## Application for a Non-Material Amendment Following a Grant of Planning Permission

Single storey kitchen pitched roof with exposed kitchen extract to be removed, and new brickwork wall with timber windows and parapet upstand to conceal flat roof over installed to match in with existing elevation

PHD DRAWN	DRAWN REVISION	24/01/23 DATE	YER
 ALLISON PIKE ARCHITECTS & DESIGNERS			
PROJECT ROBINSONS BREWERY YE OLDE BOOTE INN, OSWESTRY			
TITLE PROPOSED GROUND AND FIRST FLOOR LAYOUT, EXISTING ELEVATIONS, AND SITE LOCATION PLAN			
SCALE 1:500 AND 1:100 @ A1			
JOB No FRD23	DRAWING No PA13	REV A

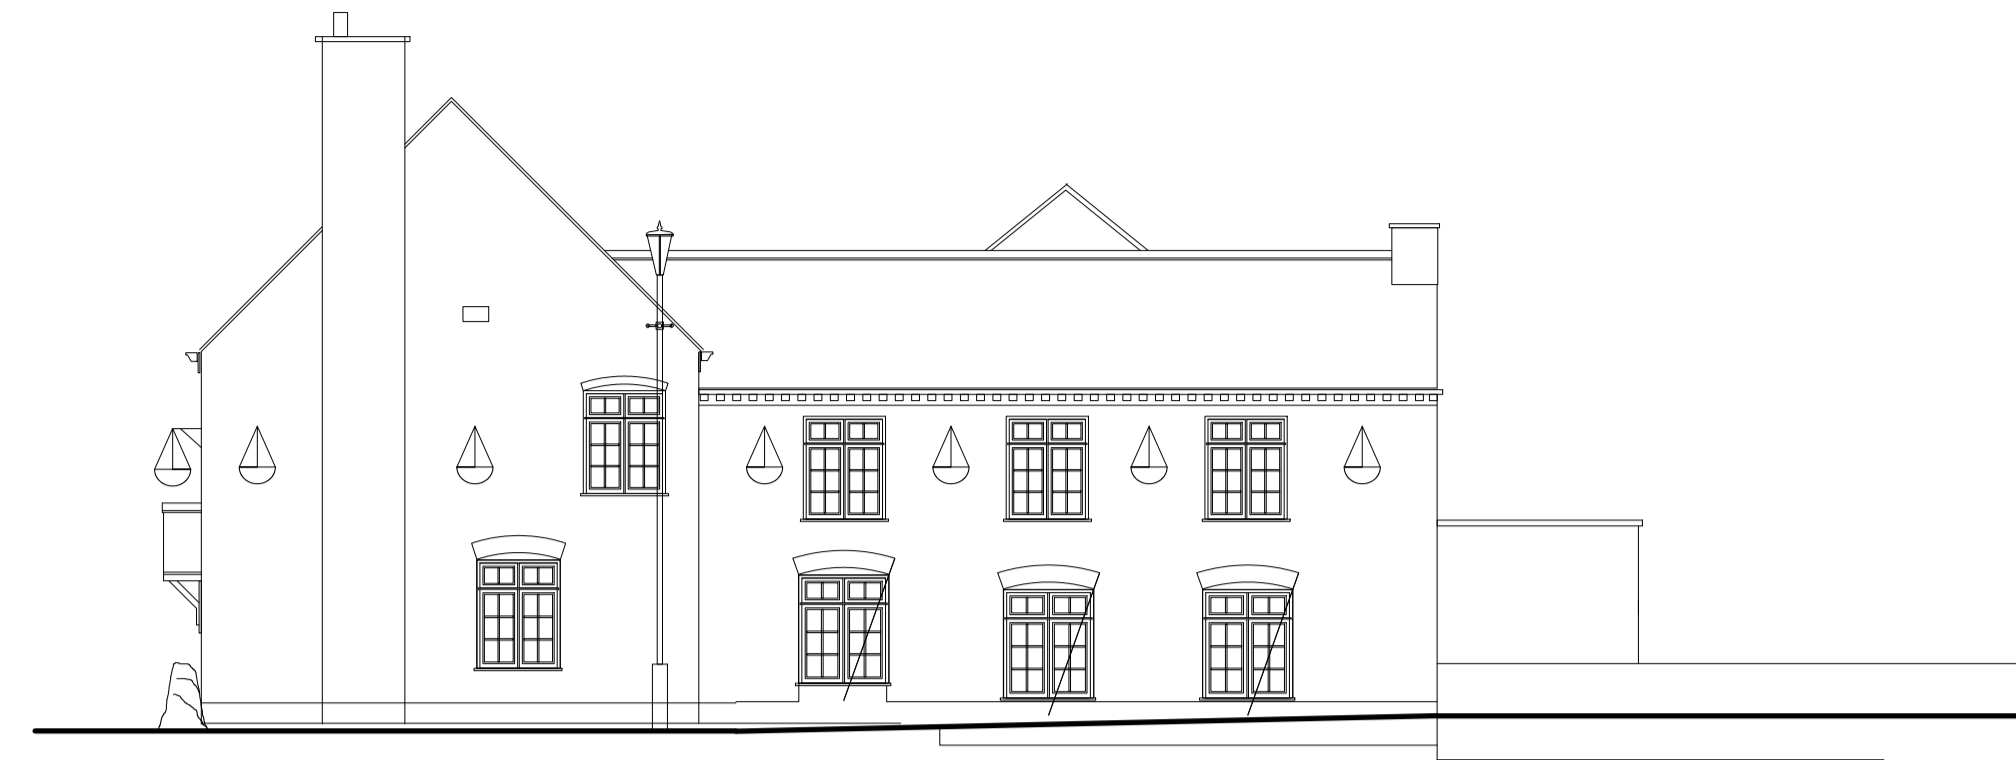
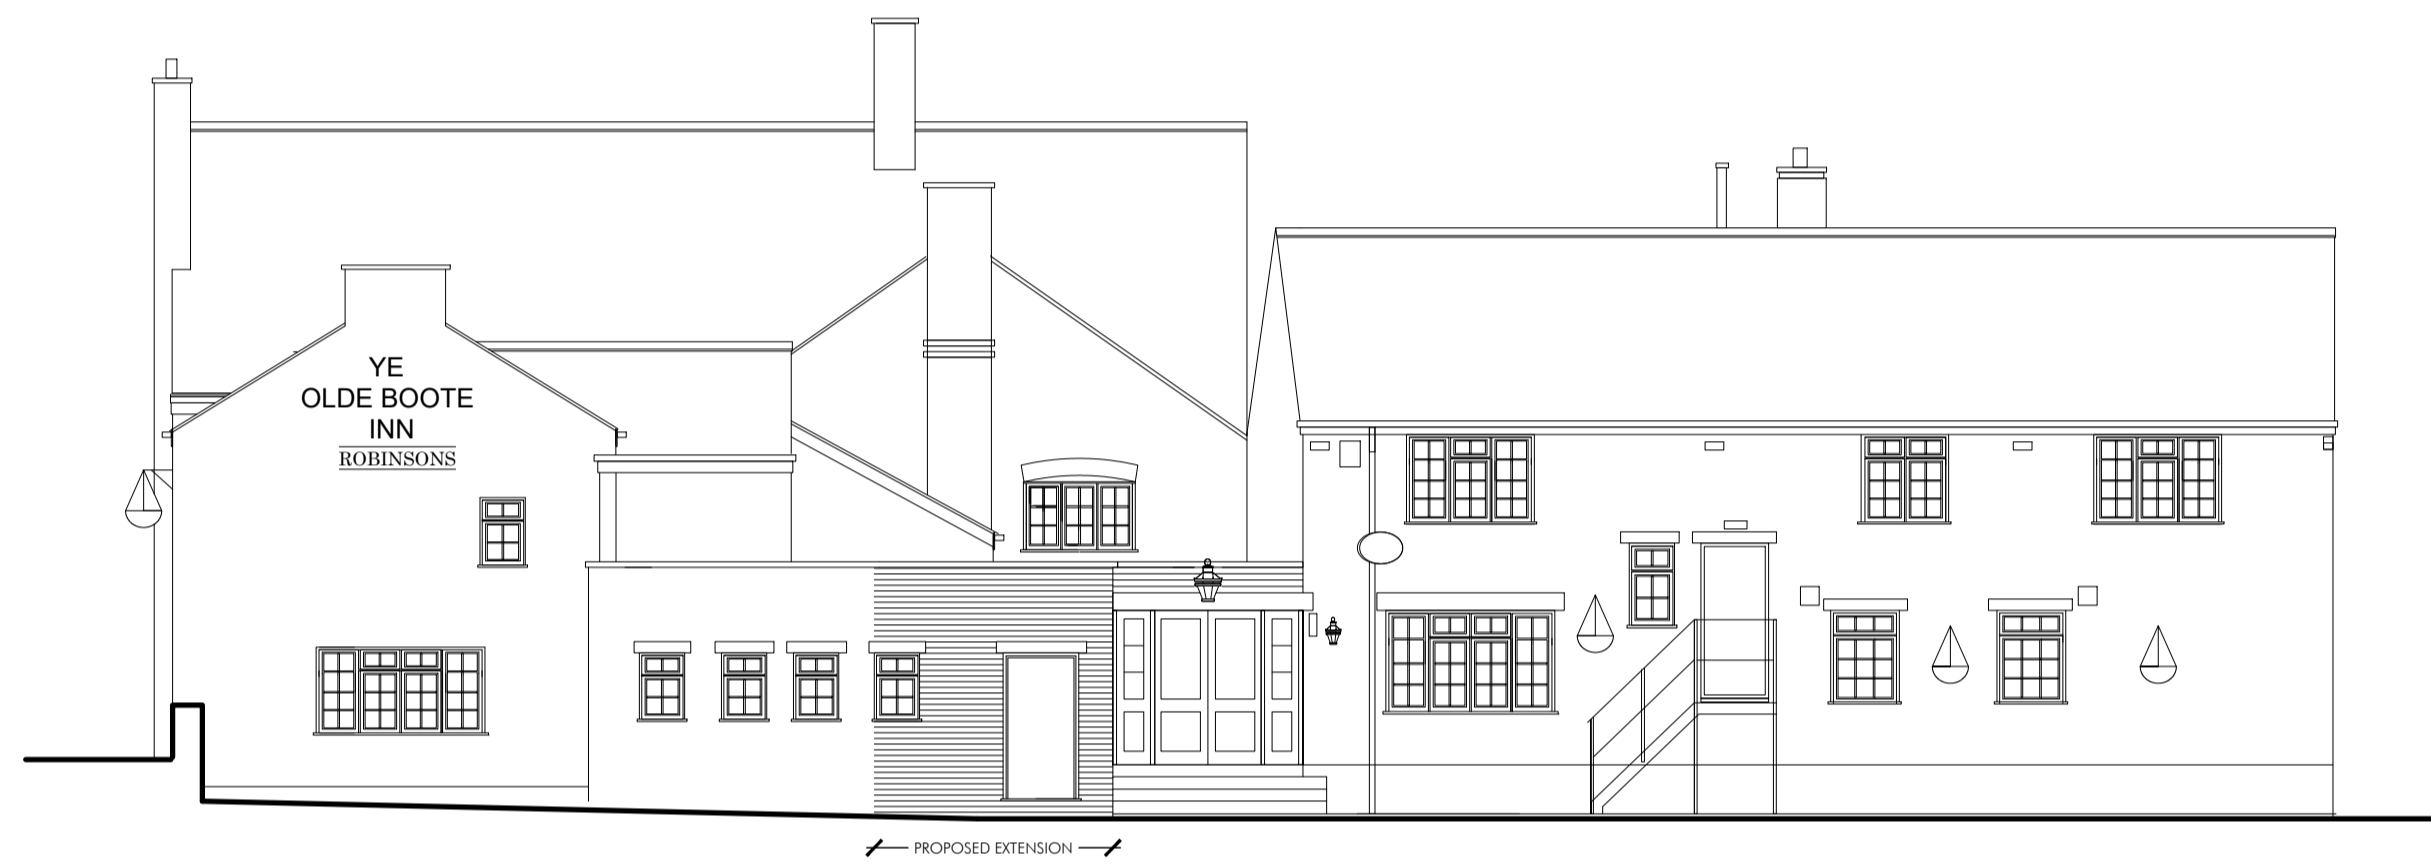
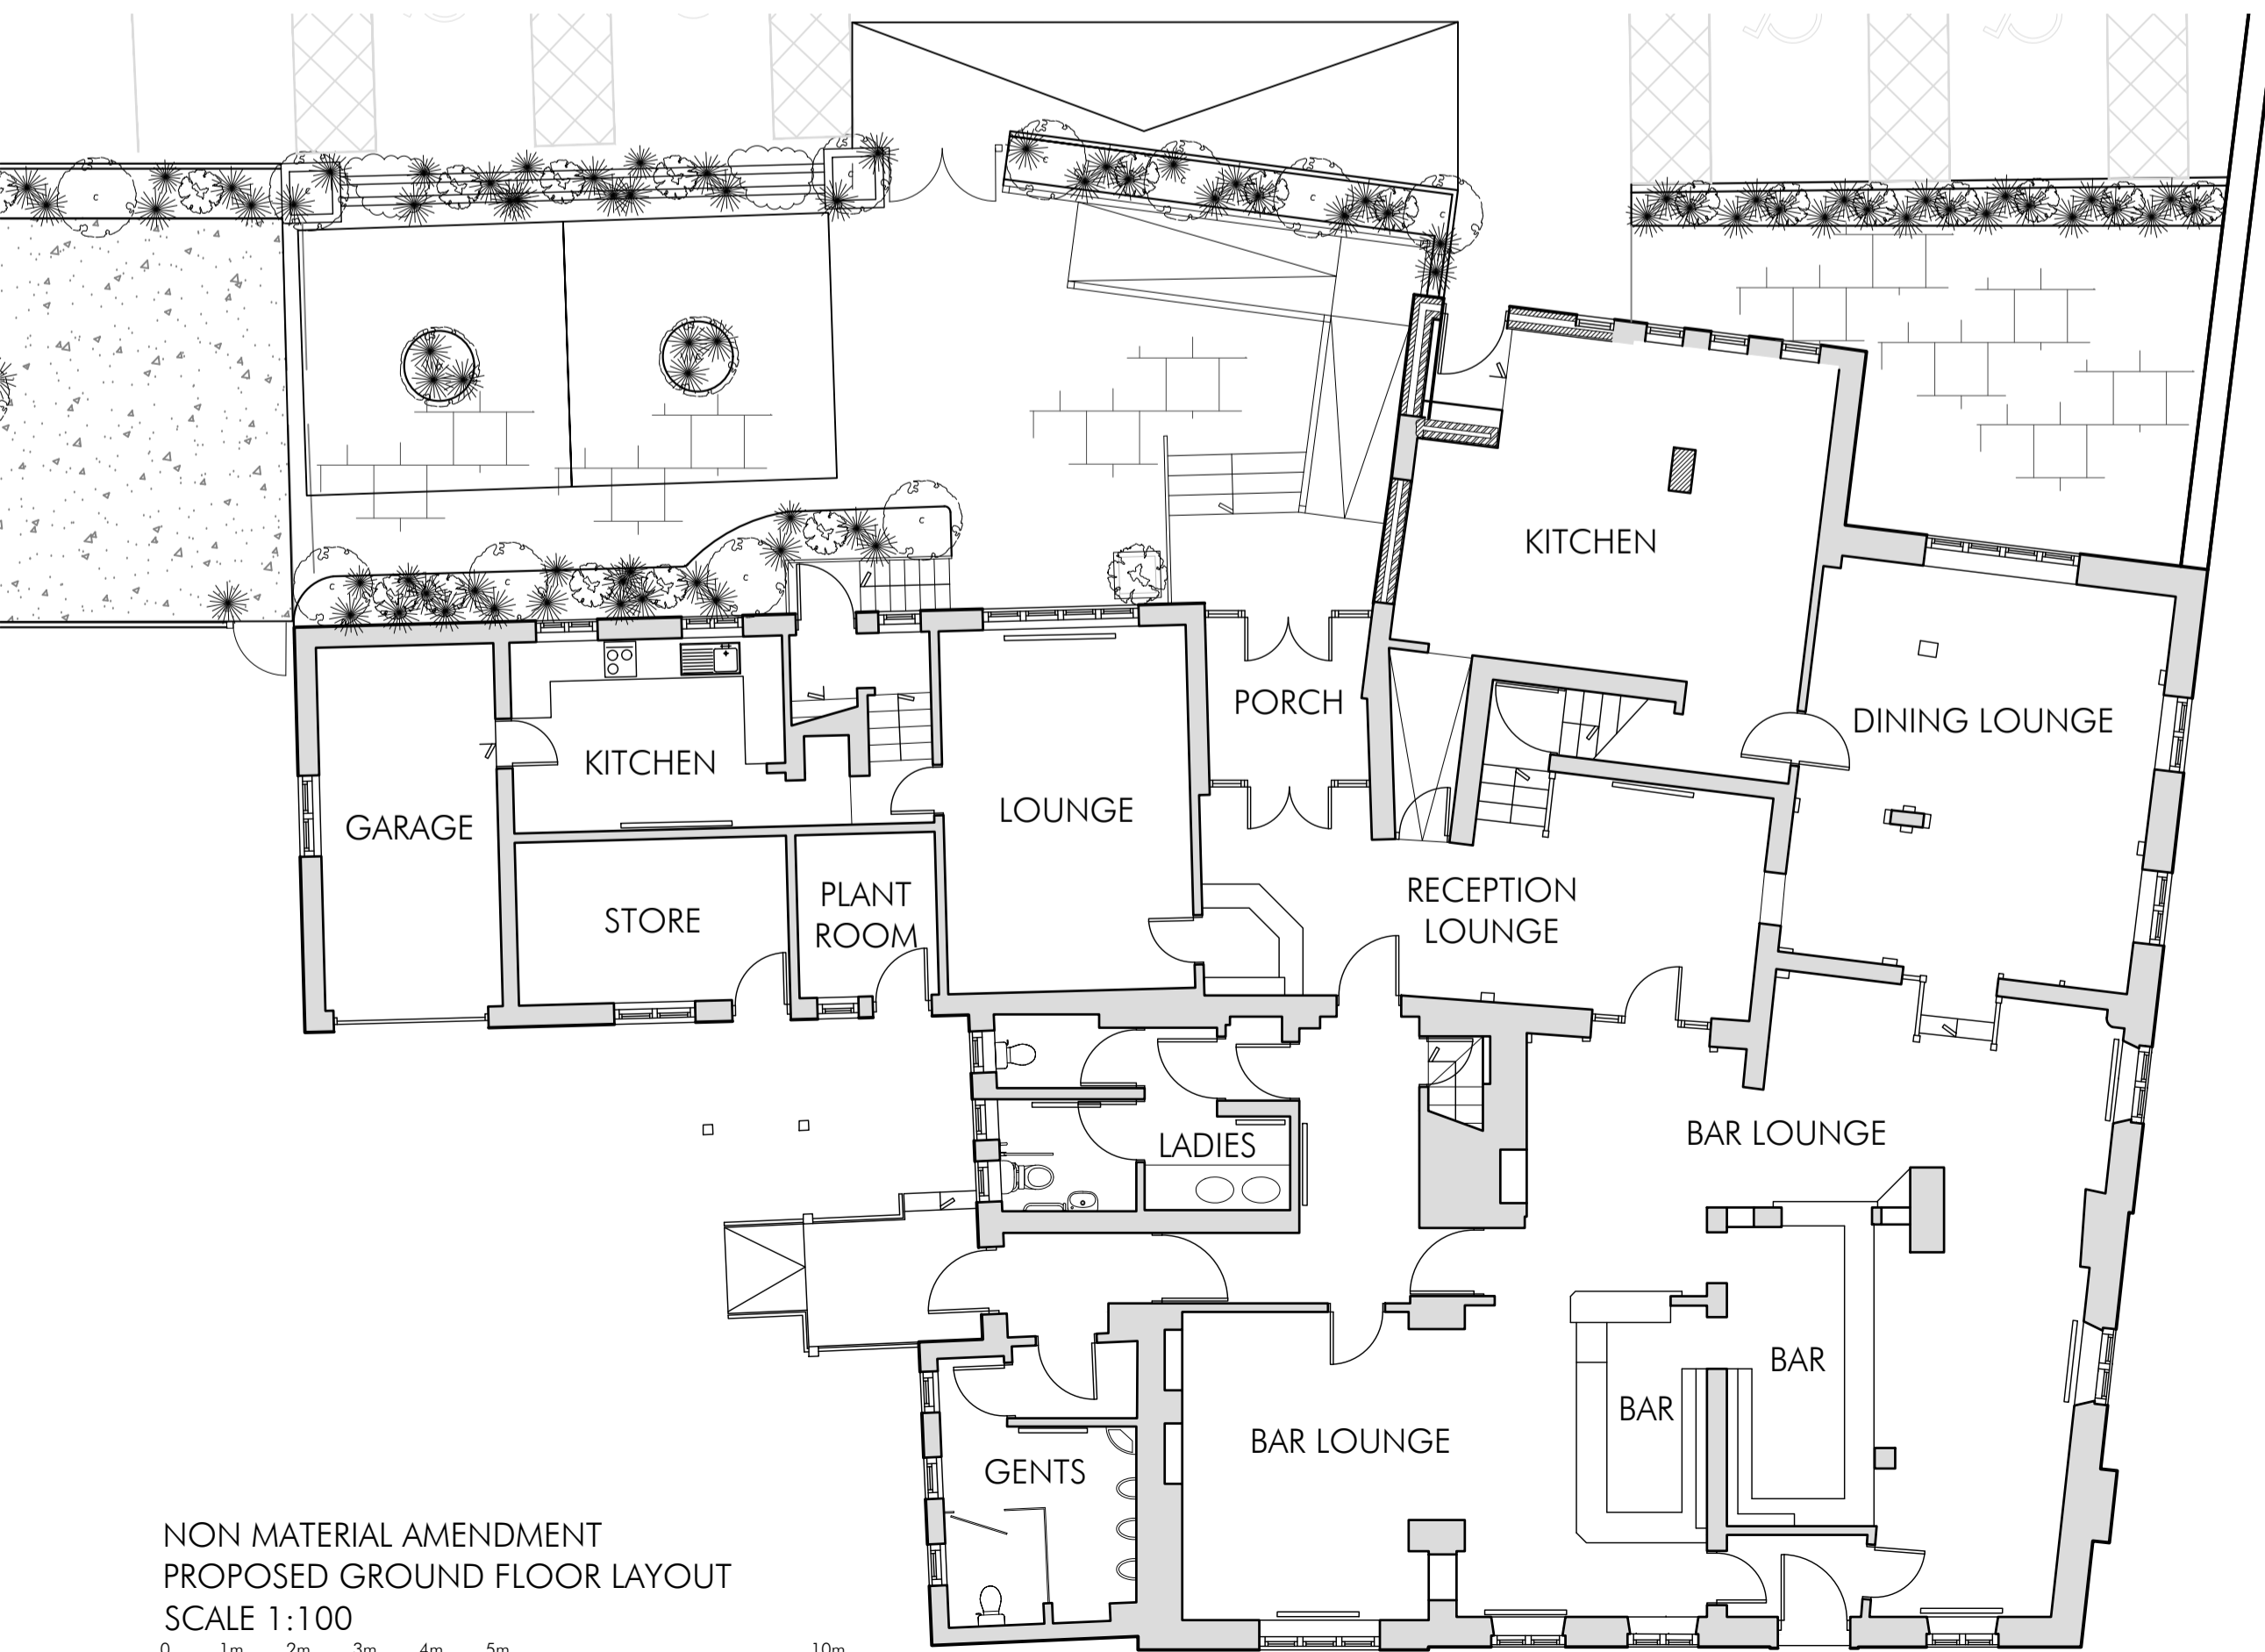
1no Door was removed from Side Elevation,  
2no windows removed from the Rear Elevation  
1no Door opening added to the Rear Elevation

To allow ramped access from the carpark into the public house
